# West Burton C (Gas Fired Generating Station)

The West Burton C (Generating Station) Order

**Applicant's Responses to ExQ1**

**Applicant: EDF Energy (Thermal Generation) Limited**  
**Date: 6 December 2019**

Drawing file: EN010088 / EN010088-000347-5.2 - WBC - ES Figure 16.2 - Short List of Development Considered for Cumulative Impact Assessment.pdf

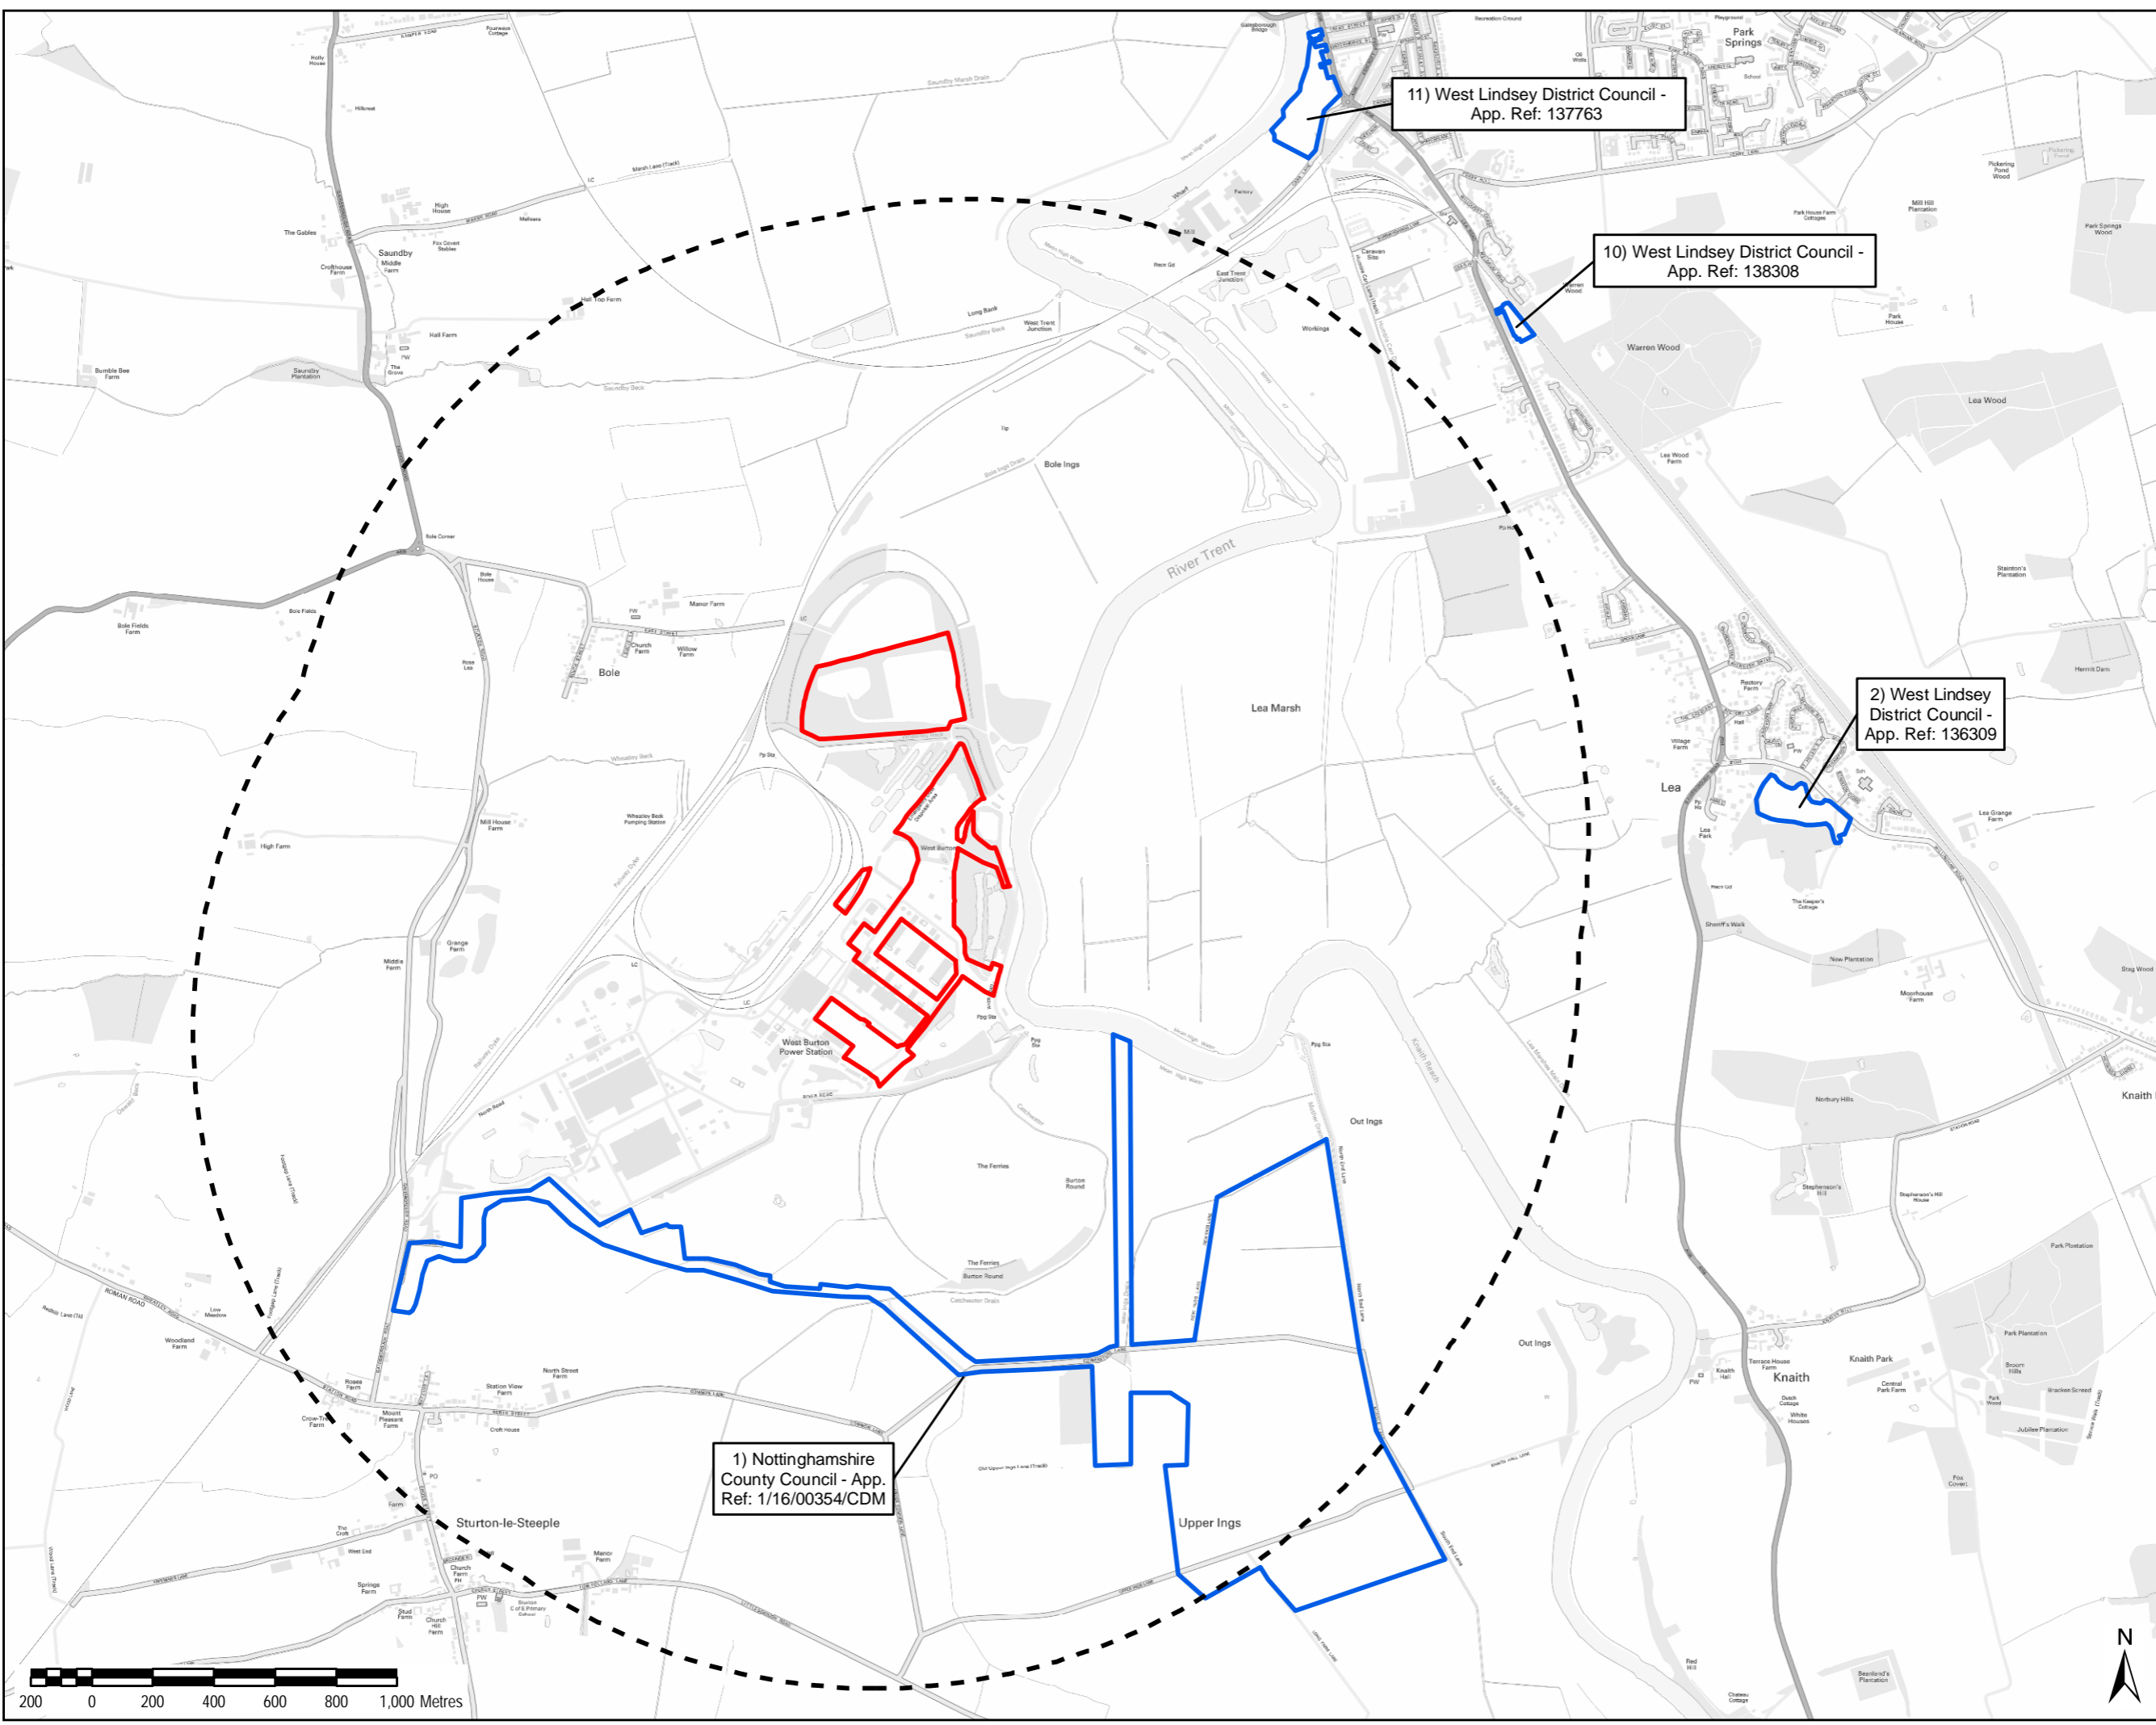
Q1.8	The Applicant, Bassetlaw District Council and West Lindsey District Council	Has the shortlist of major projects in respect of the assessment of cumulative effects identified in Table 16-5 of ES Chapter 16 [APP-045] and on ES Figure 16.2 [APP-131] been agreed with/by the relevant local authorities?	<p><b>Table 16-3 of APP-045 (Chapter 16: Cumulative and Combined Effects)</b> sets out the consultation process undertaken for this ES Chapter and the comments received from relevant stakeholders and addressed by the Applicant. The relevant local authorities were invited to comment on the list of schemes considered in the cumulative impact assessment from an initial list provided in <b>APP-046 (Appendix 1A: the EIA Scoping Report)</b> and then the short-list considered in Chapter 16: Cumulative and Combined Effects, of the Preliminary Environmental Information Report. Each local authority was also provided with a final draft copy of Chapter 16: Cumulative and Combined Effects, prior to submission of the Application. This included the short-list of major projects, with the offer of a pre-application meeting to discuss the proposals and feedback on the Application documents. Meetings held with and feedback received from West Lindsey District Council are described in the Statement of Common Ground agreed with the authority and submitted at Deadline 1 (<b>REP1-012</b>). The same approach is taken in the Statement of Common Ground in discussion with Bassetlaw District Council, which will be completed and submitted at the subsequent Examination Deadline. Through the finalisation of these SoCGs, '<i>It is further agreed that the short list of committed developments for cumulative effects assessment was appropriate at the time of the Application.</i>'</p>
